72 BISHOP STREET  
Portland, Maine  
Bishop Street

Date: **SEPTEMBER 9, 2015**

Title:  
SUBDIVISION PLAT PLAN

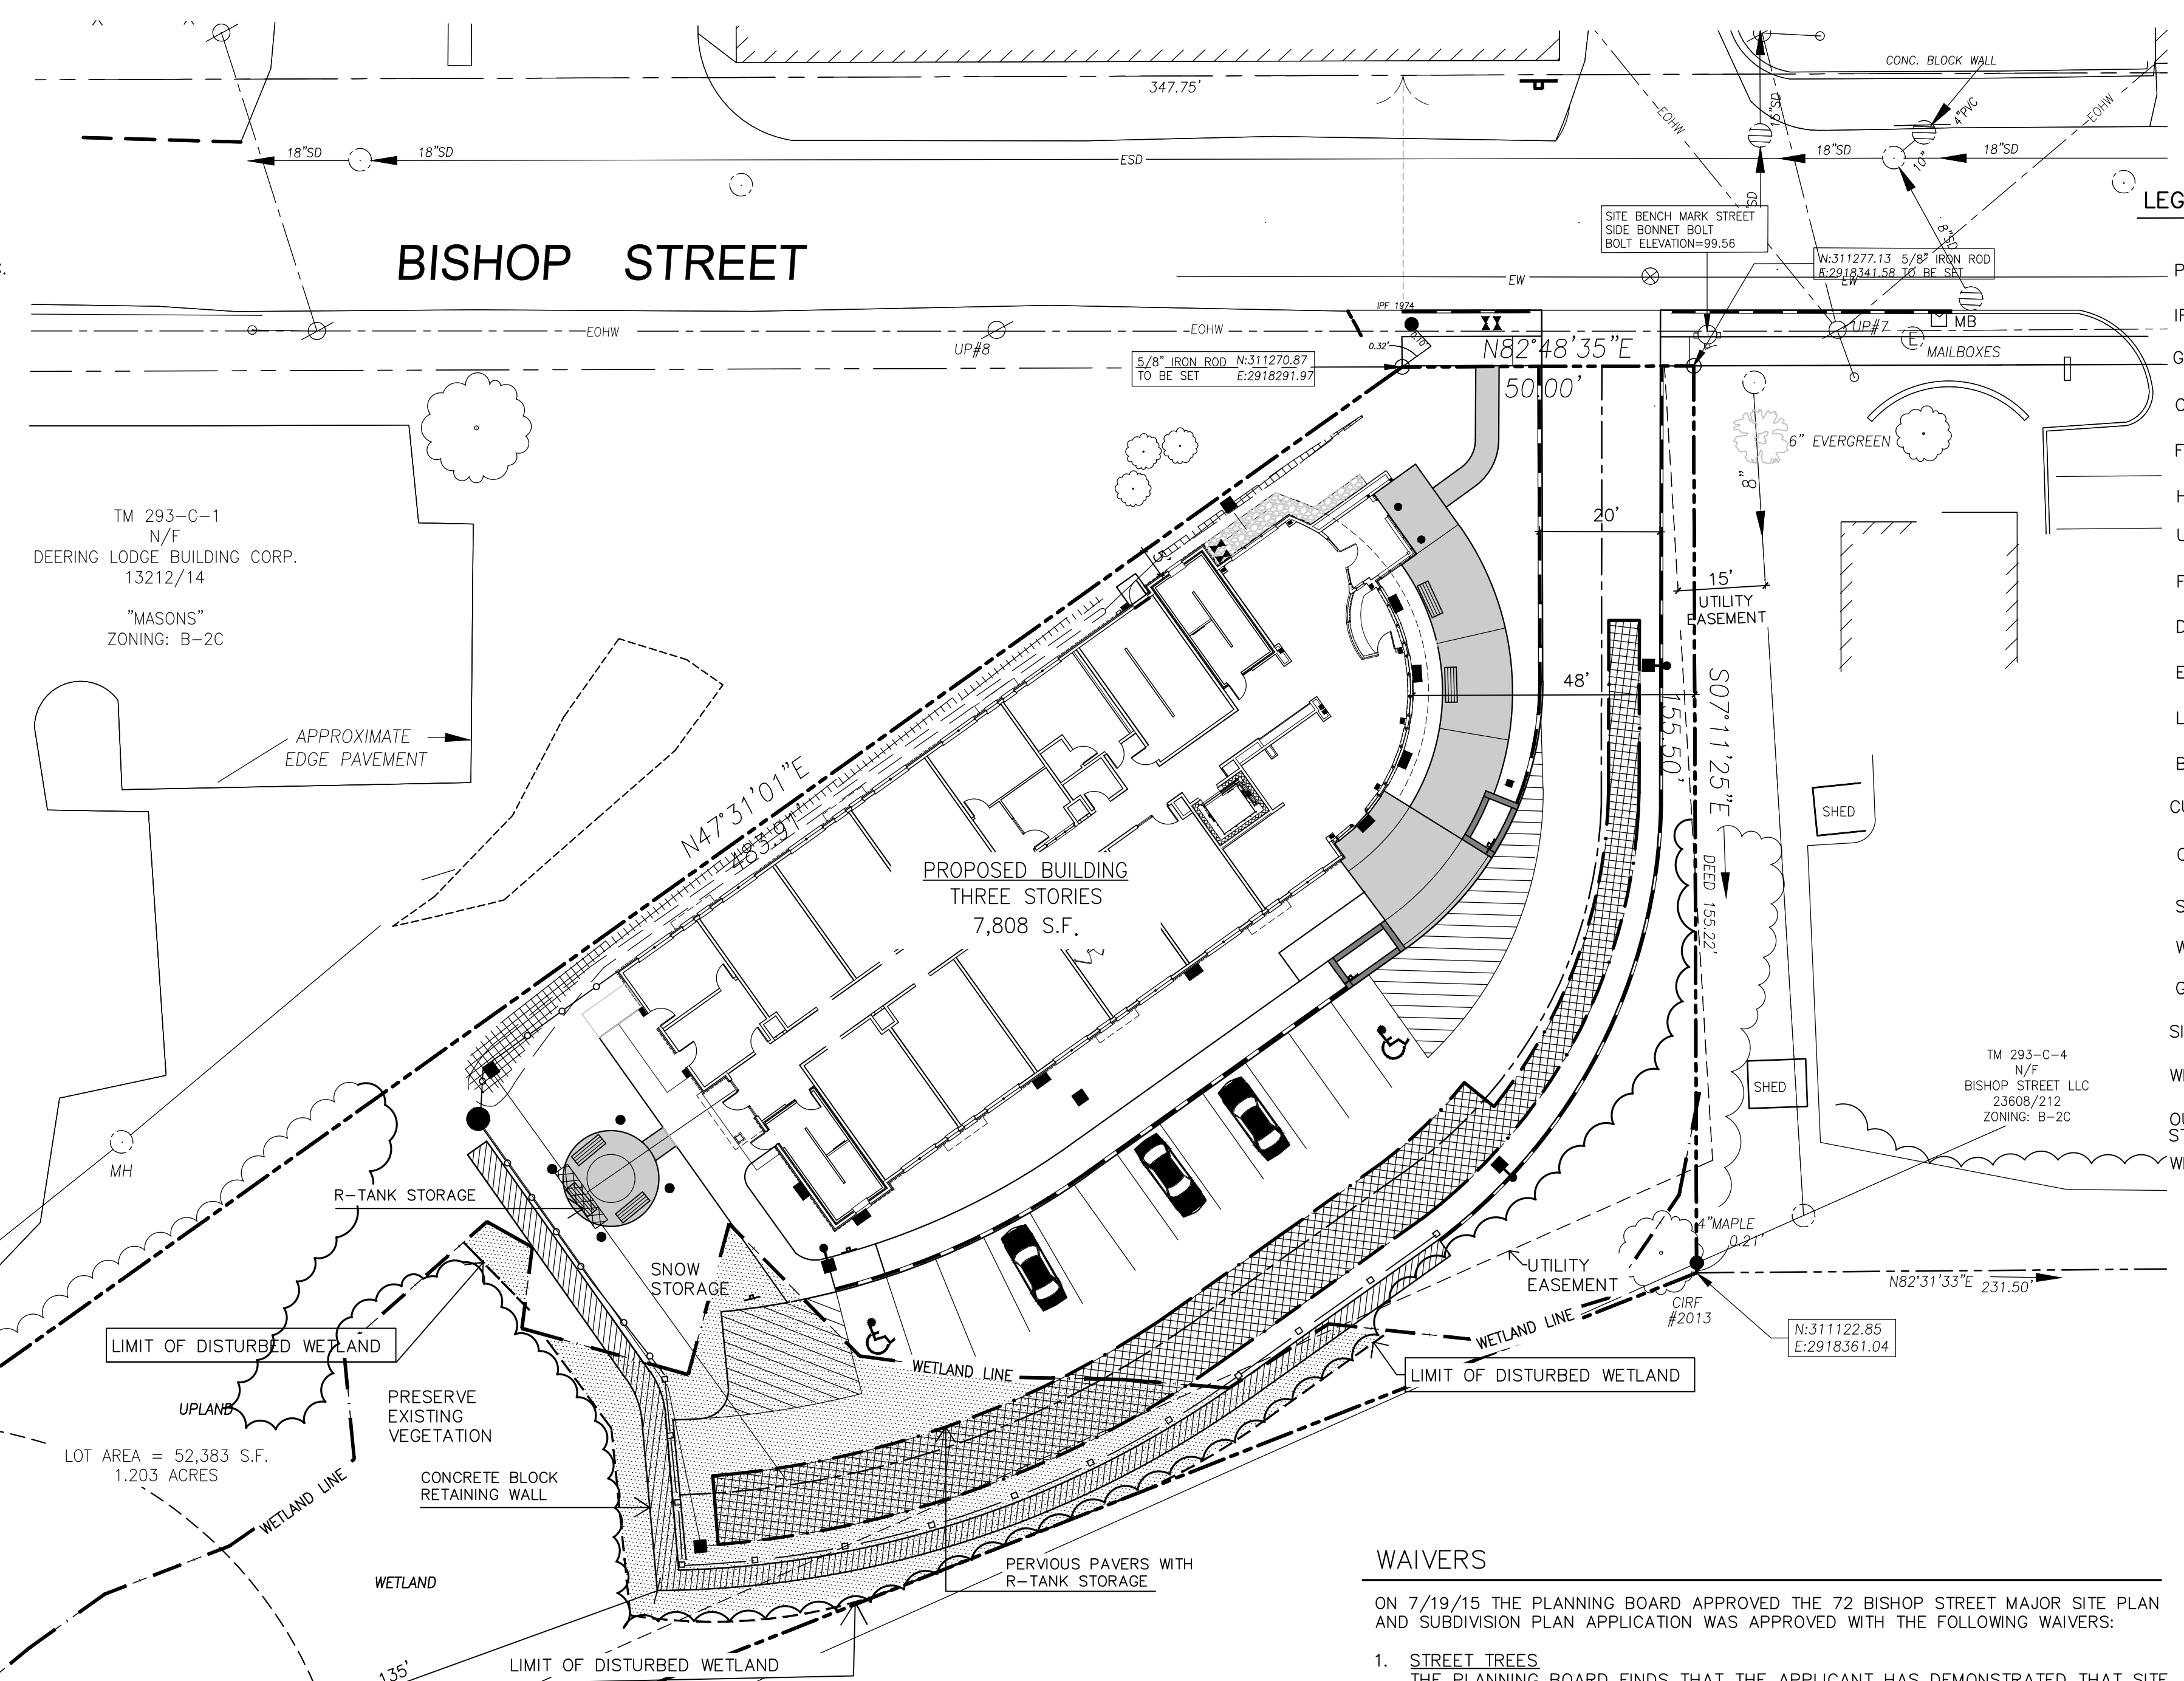
- BEARINGS ARE GRID NORTH AND ELEVATIONS ARE NAVD88 AS BASED ON STATIC GPS COLLECTION AND OPUS CORRECTION. **SEE NOTE RE DATUM FROM BIN CLARK**
- WETLAND DELINEATION PERFORMED BY C.E.S. INC., LEWISTON MAINE, JUNE 2014. FLAGGED WETLAND AREA WAS SURVEYED BY OWEN HASKELL, INC., FALMOUTH, MAINE, JULY 2014.

- PRIOR TO SITE CLEARING, CONTRACTOR SHALL COORDINATE WITH PROJECT LANDSCAPE ARCHITECT TO DEMARCATTE TREES FOR PROTECTION AND WETLAND AREAS TO BE PROTECTED. EXISTING TREES TO BE PRESERVED SHALL BE PROTECTED DURING CONSTRUCTION AND SHALL BE THE RESPONSIBILITY OF THE GENERAL CONTRACTOR. **SEE NOTE TO SHEET L4**

**23 REFER TO STORMWATER SYSTEM + SITE CONDITION RE STORMWATER FROM APPROVAL LETTER.**

**24 NOTE RE HANDLING TRASH?**

**ON 2/4/15 THE PB APPROVED THE NOTE APPROVAL LP. 2**

- THE FOLLOWING EASEMENTS ARE CONNECTED TO 72 BISHOP STREET:
- A 30' UTILITY EASEMENT EXTENDS ALONG THE SOUTH WESTERN END OF THE PROPERTY TO ACCOMMODATE AN EXISTING CITY OF PORTLAND STORM DRAIN **BOOK - PIPE**
  - MASSONIC LODGE? **BOOK - PIPE**

- THE DEVELOPMENT PROPOSED AT 72 BISHOP STREET REQUIRES THE FOLLOWING PERMITS:
- NRPA TIER 1 WETLAND ALTERATION PERMIT **PBR - CITE**
  - GENERAL CONSTRUCTION PERMIT **CITE #/DOCUMENTATION**
